Application No: AB/6/25/PL

Site Address: Sparks Yard 18 Tarrant Street Arundel BN18 9DJ

Description of works: Conversion of existing single residential unit with associated commercial space to form 3 No. residential units together with associated works and rear/side extension. This application affects the setting of listed building, affects the character and appearance of the Arundel Conservation Area, is in CIL Zone 2 and is CIL Liable as new flats.

Thank you for your internet representation made on 17th February 2025 which has been recorded as an objection with the comments as follows:

BLOCK PLAN

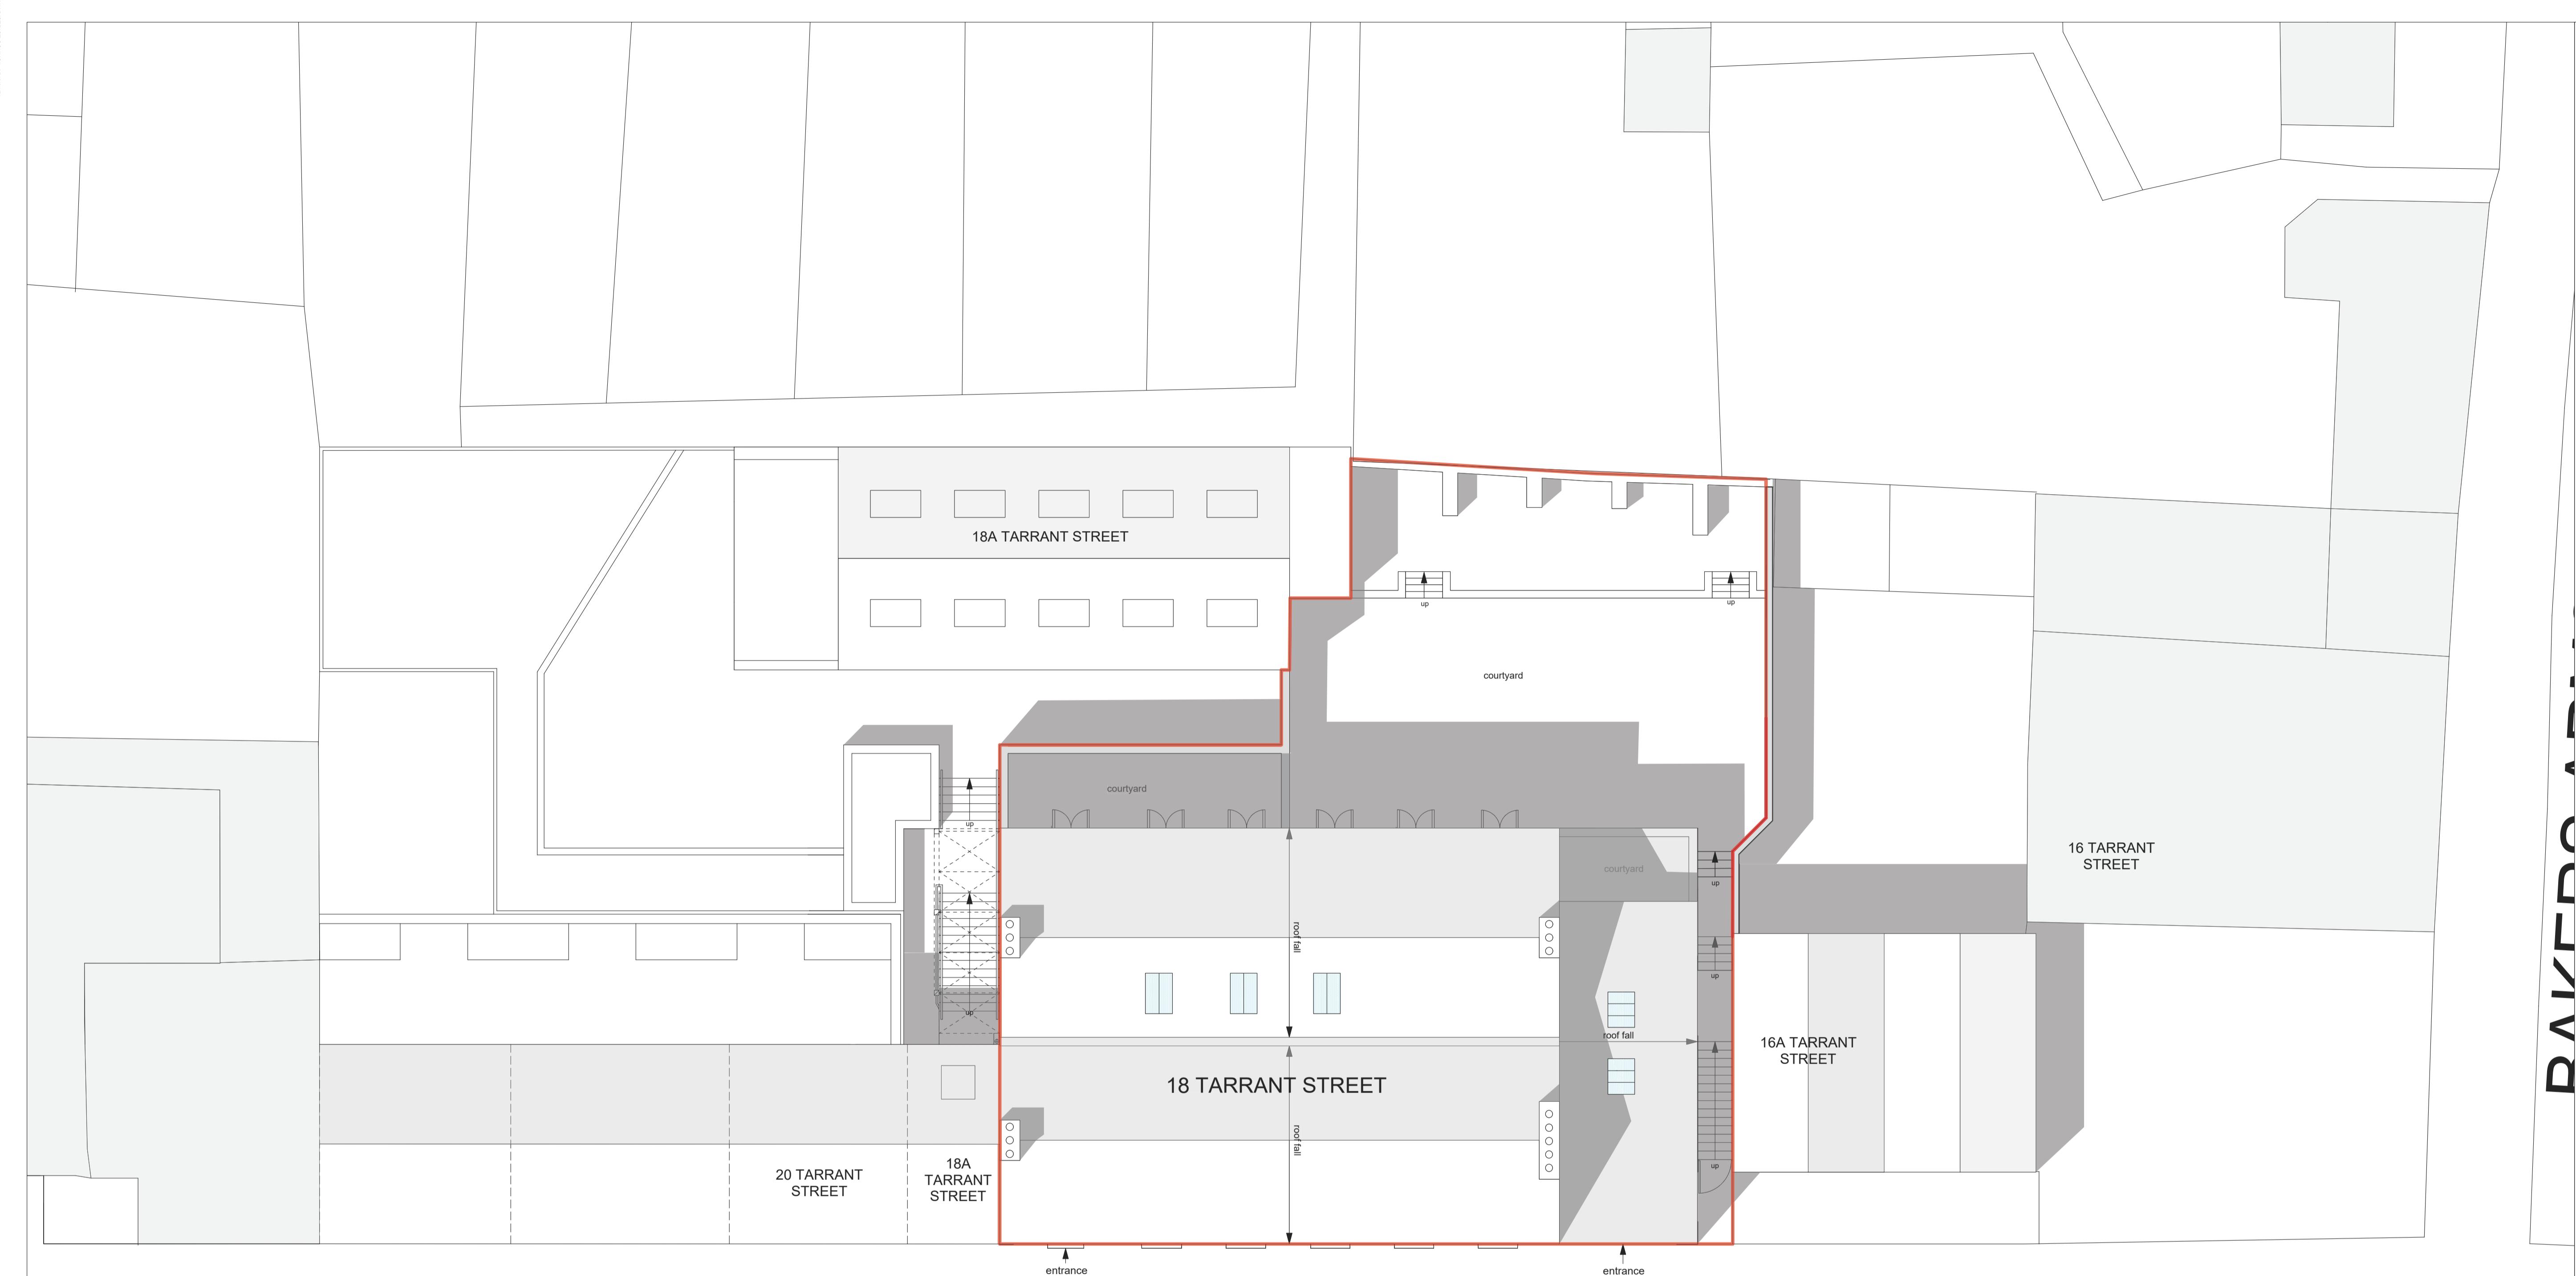
- 1.) The buildings are only 3.6 meters apart north to south elevations
- 2.) The windows on the 2nd floor of Sparks Yard are directly aligned with the Piano Store. Therefore, the conversion of Sparks Yard into multiple houses/ occupancy, with either bedroom or living space would have a huge impact on the privacy of the Piano Store. Any new occupiers would be looking directly into our bedroom spaces.
- 3.) The windows on the 2nd floor western elevation look directly over and down into the garden of the piano store. Conversion into living or bedroom areas at this end of the building would again severely impact our privacy and ability to enjoy the amenities of our garden.
- 4.) The windows on both the north and west elevation of Sparks Yard were historically fitted with an opaque which in the past protected the privacy of the Piano store. This has recently been removed.

As a last point we do recognise that Sparks Yard needs to find its future use. If the application was amended, or a condition is attached to the planning consent which ensured that the windows we have highlighted are fitted with permanent opaque glass or a fixed louvres system which preserved both parties' privacy then we would have no broader objection and could support the application. This would seem a very fair request as the conversion could proceed into 3 residential units but at the same time our privacy and use of the amenities of our property could be preserved. Hopefully a win win for all.
